Rezoning Transportation Analysis

Petition Number: 2019-128

From: Lakisha Hull, LEED AP BD+C, AICP

Date	Description
10-21-2019	First Review (EL)
06-26-2020	Second Review (EL)
08-21-2020	Third Review (KP)

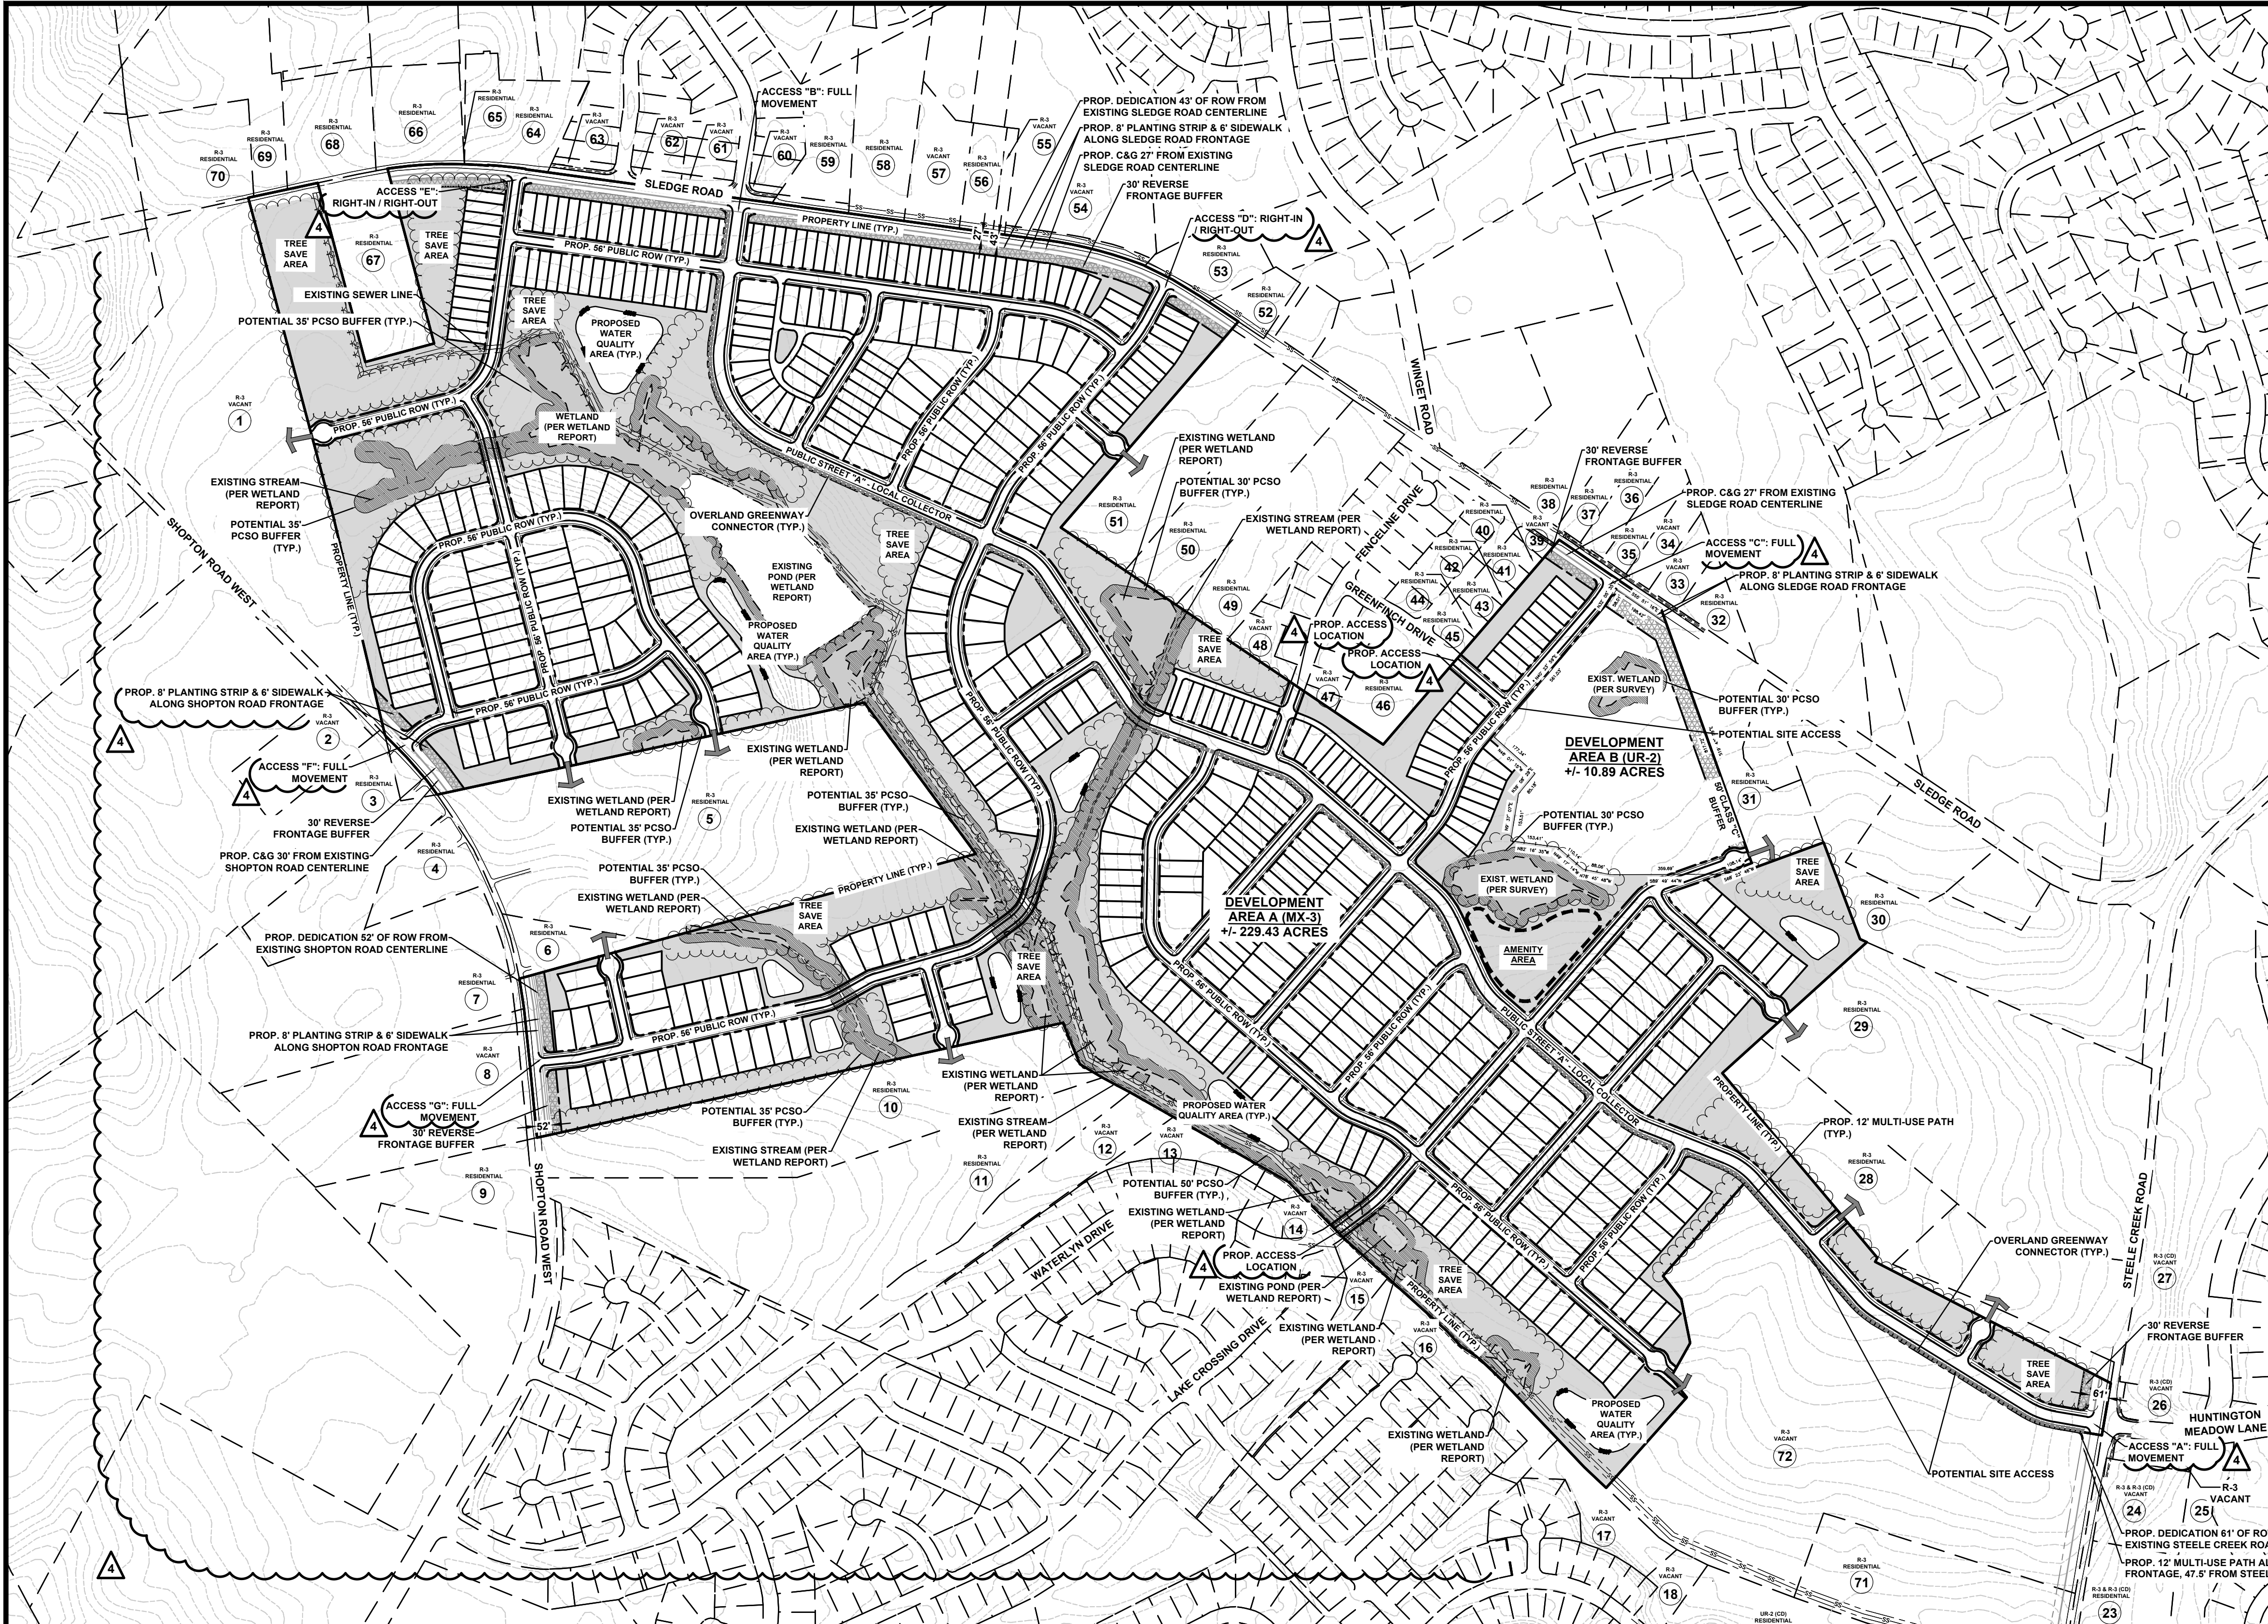
1. **Curbline** The proposed zoning district has a setback measured from back of the existing or proposed future curbline. **Updated Comment: The curb lines should be dimensioned from the centerline. TYP.**
 - a. **Steele Creek Road:** The future location of curb and gutter will be constructed within the Steele Creek Road (NC 160) U-5766 project. The public meeting map and proposed cross section are provided below for reference.

4. The petitioner should revise the site plan and conditional note(s) to commit to construct an 8-foot planting strip and 6-foot sidewalk along the frontage of Sledge Road. The site plan should label and dimension both items from the back of curb and gutter and road centerline. **Update to Comment: This planting strip and sidewalk should be included along the frontage near access F.**

6. The petitioner should revise the site plan and conditional note(s) to commit to construct a 6-foot sidewalk along of the frontage of Shopton Road and to establish a connection to the existing sidewalk stub provided by the existing Waterlyn Subdivision. The site plan should label and dimension both items from the back of curb and gutter and road centerline.

8. The petitioner should revise the site plan and conditional note(s) to commit to donating a temporary construction easement to NCDOT, when NCDOT proceeds with real estate acquisitions to construct the NC-160 (U-5766) STIP, along the development's frontage of Steele Creek Road.

10. The petitioner should revise the site plan and conditional note(s) to specify each proposed street's USDG cross section.
11. ~~The petitioner should revise the site plan and conditional note(s) to propose the recommended greenway alignment to the McDowell Nature Center and Preserve, per the Council-adopted Steele Creek Area Plan.~~

- The petitioner should revise the site plan and conditional note(s) to incorporate a proposed mini-roundabout on proposed Public Street "A."

- The petitioner should revise the site plan and conditional note(s) to revise Public Street "A" to a Local Collector Street Section, per CLDSM U-07, as required by Sec. 20-23(k) of the Subdivision Ordinance and the City-council adopted Collector Street Map. ~~In lieu of the proposed 10-foot multi-use path, a 12-foot multi-use path should be provided along the western streetscape to provide an overland connector to the recommended greenway alignment to the McDowell Nature Center and Preserve.~~

14. The petitioner should revise the site plan and conditional note(s) to establish a street connection to "Development Area C."
